Item No. **Report of the Head of Planning, Building Control, Sport & Green Spaces**

Address 734-736 UXBRIDGE ROAD HAYES

Development: Change of use of first and second floors from offices (Use Class B1) to a 10 bedroom House in Multiple Occupancy, involving installation of roof lanterns to first floor roof and installation of metal gates to side (Sui Generis)

LBH Ref Nos: **18920/APP/2015/2042**

sd00738/PL10  
REV A

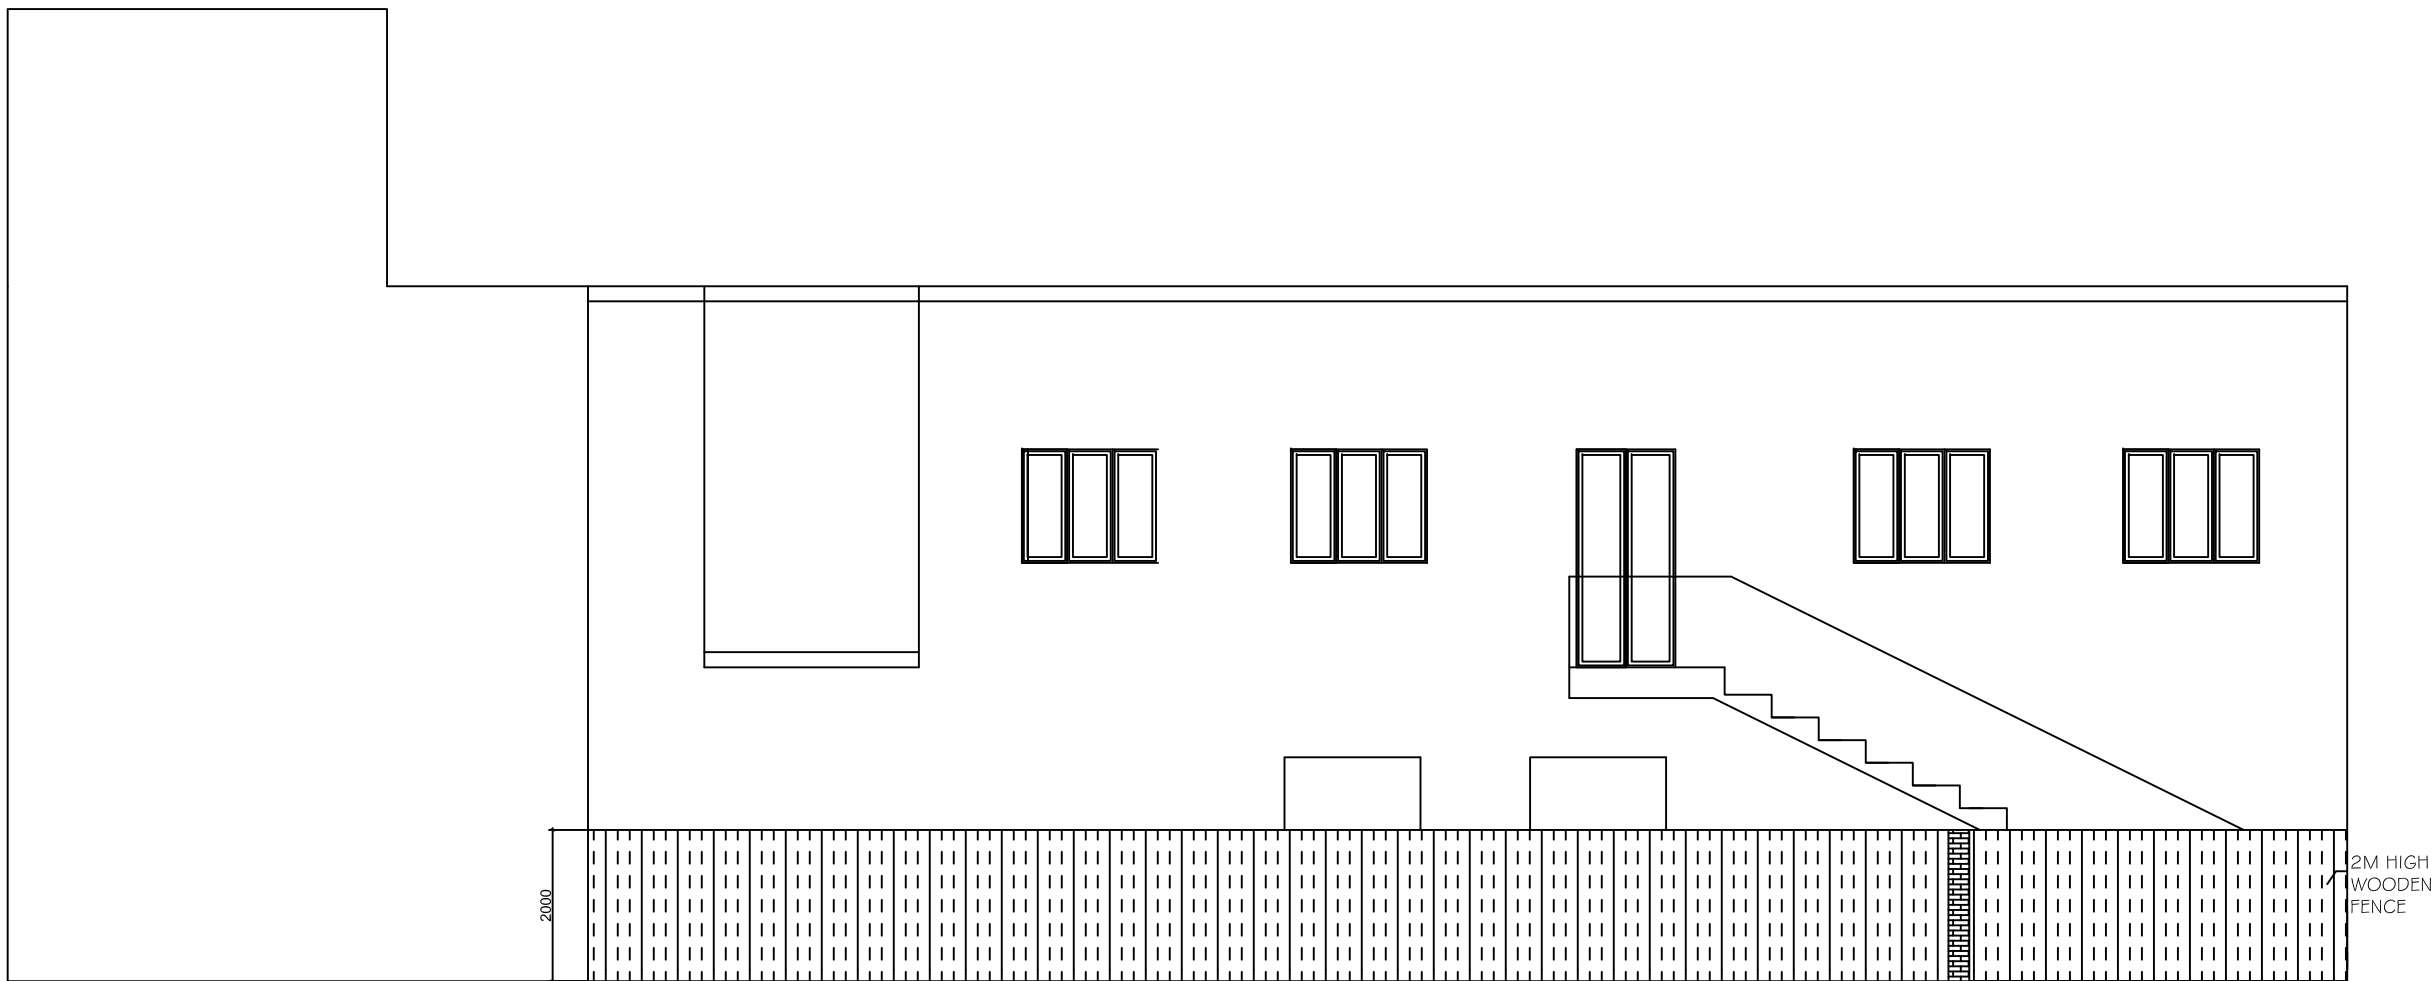
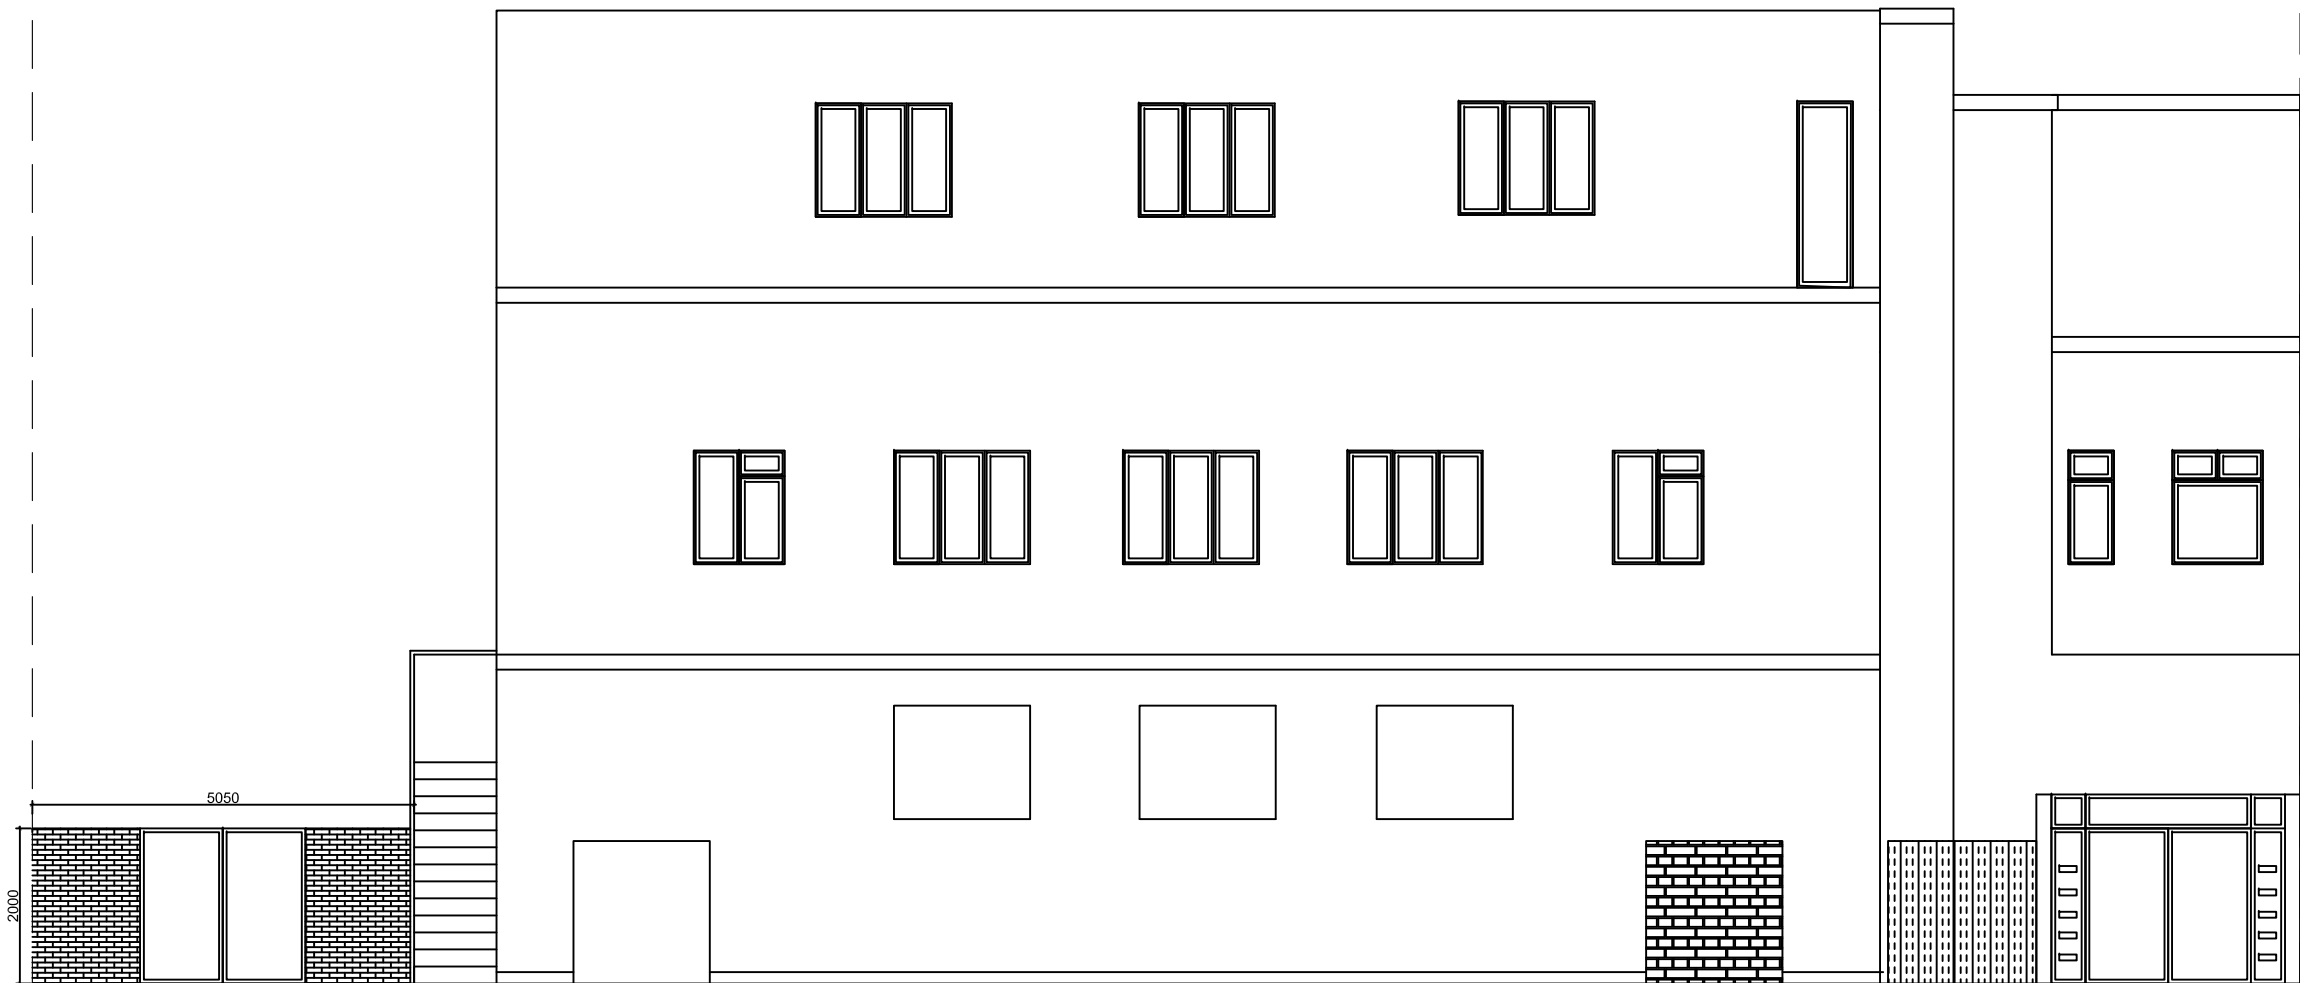
The proposal does not include any external alterations to the main building and the installation of the gates, measuring 2m in height are considered to respect the character and appearance of the rear of the site. As a result it is considered that it would not have a negative impact upon the visual amenity of the site or the surrounding area in compliance with Local Plan policies BE13 and BE15.
